Front, side & rear extensions (resubmission following EP/112/14/HH).
19 Selborne Way East Preston

Thank you for your internet representation made on 24th March 2015 which has been recorded as '**an objection**' with the comments as follows:

I am commenting on this application on behalf of the East Preston and Kingston Preservation Society.

DRAWING TITLE
PROPOSED FLOOR PLANS

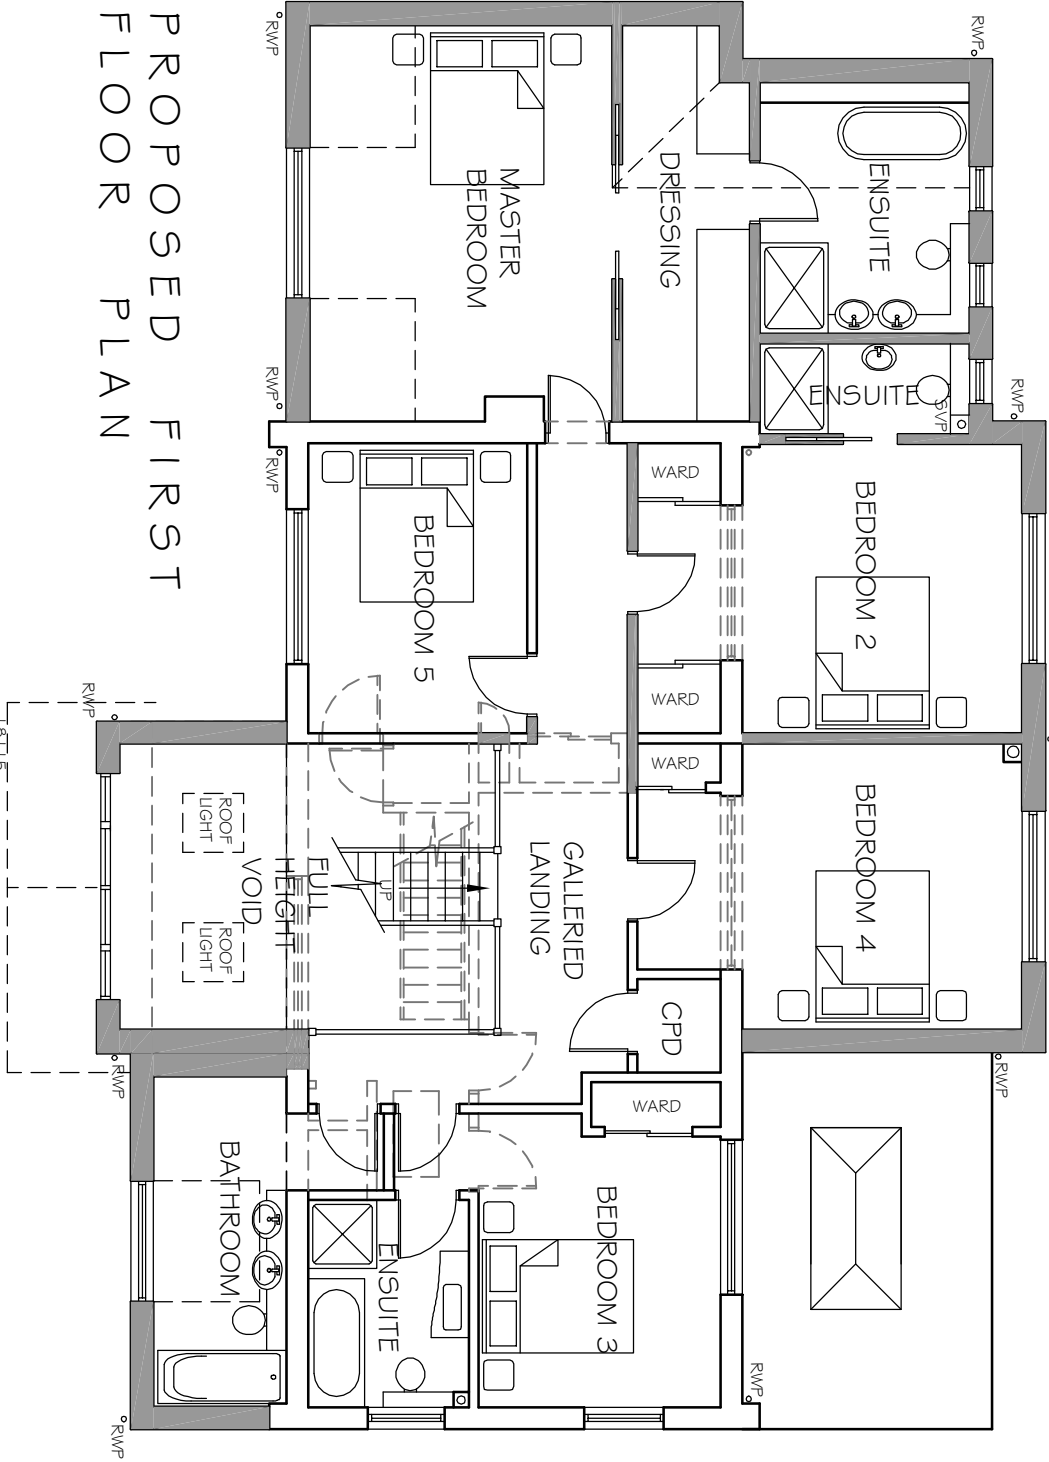
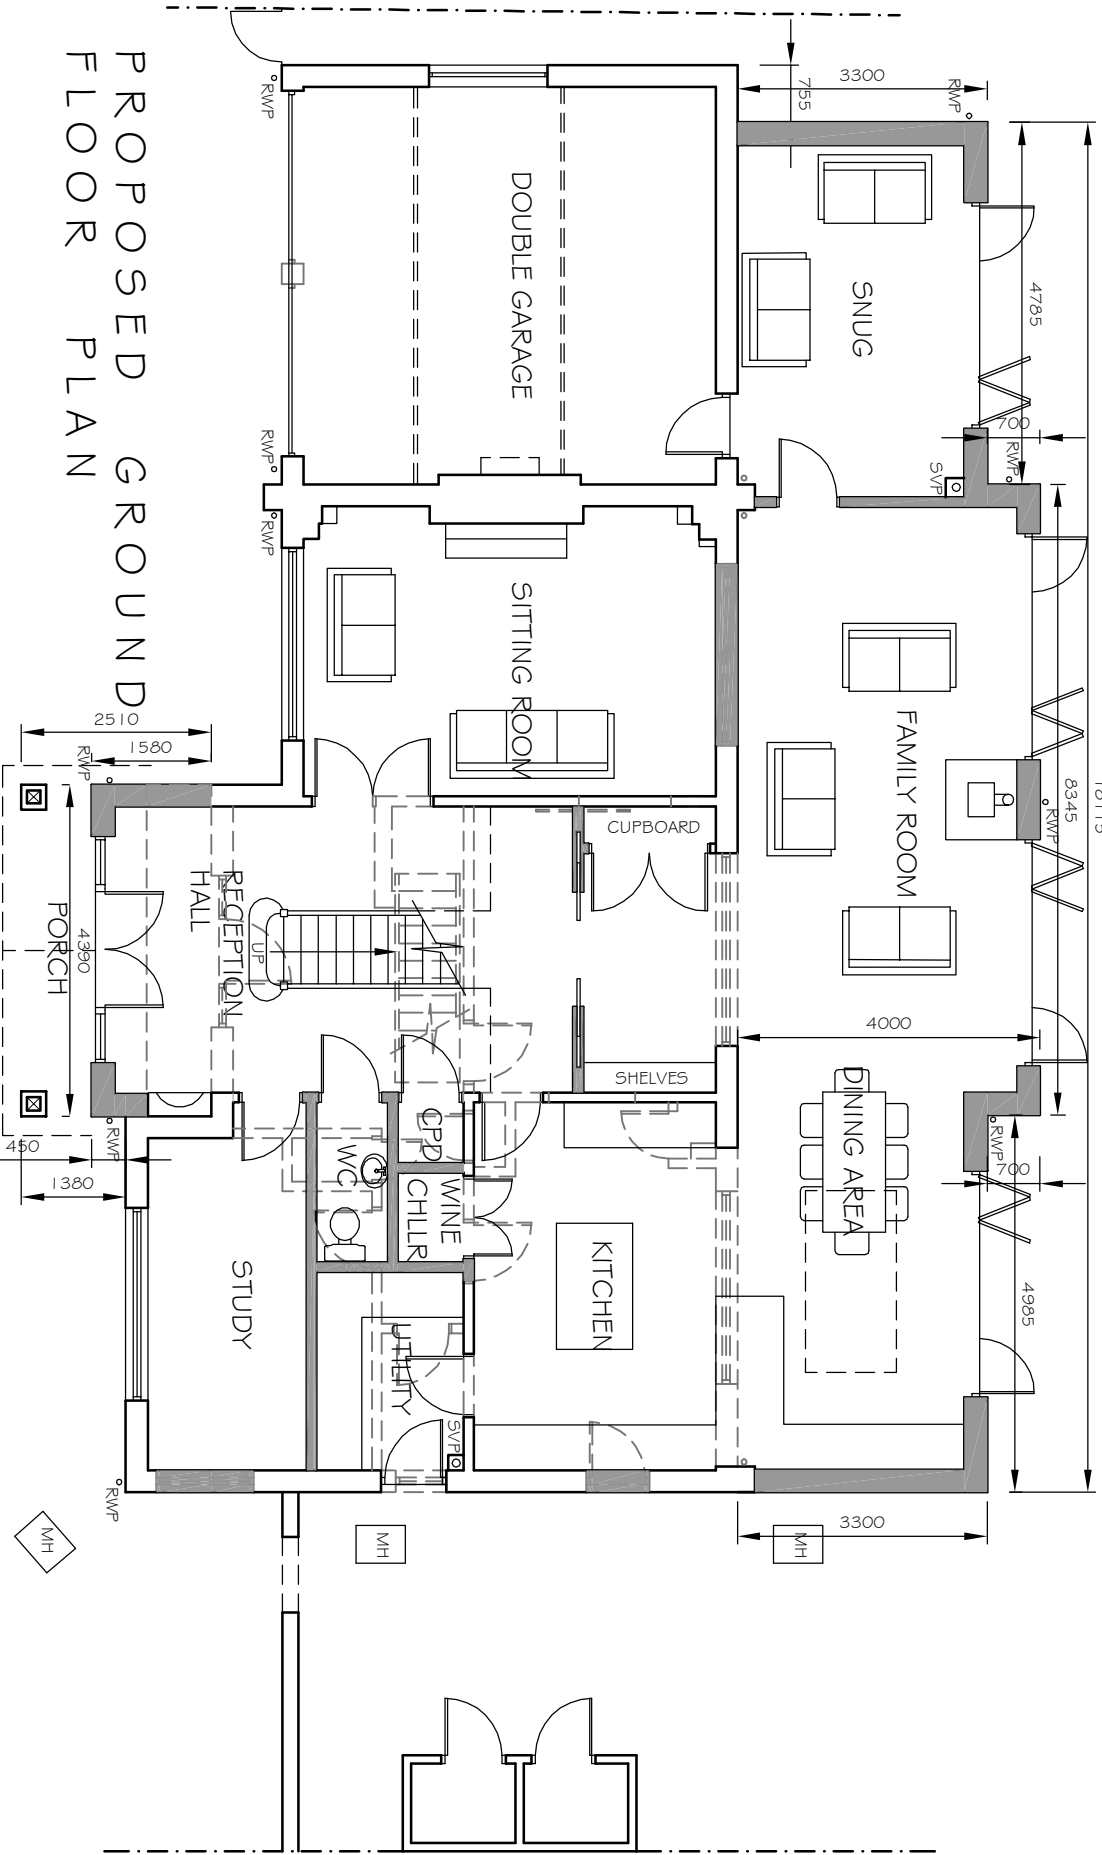
The proposal conflicts with the Neighbourhood Plan because the alterations, especially the large glass front porch and the Cedrol cladding at first floor level, do not look part of the original design of the house and do not harmonise with other buildings in the road in either design or materials. The materials should harmonise in both colour and texture with those in adjoining buildings. (Paras. 4.12 and 4.16 EPNP).

The proposals conflict with policy D DM4 of the draft Arun Local Plan because the alterations do not sympathetically relate to the existing house and are not visually integrated with it; and conflict with para. 13.4.4 because the altered house does not respect its surroundings. The altered house would instead clash with the appearance of its neighbours and the large front porch would be somewhat overbearing in the street scene.
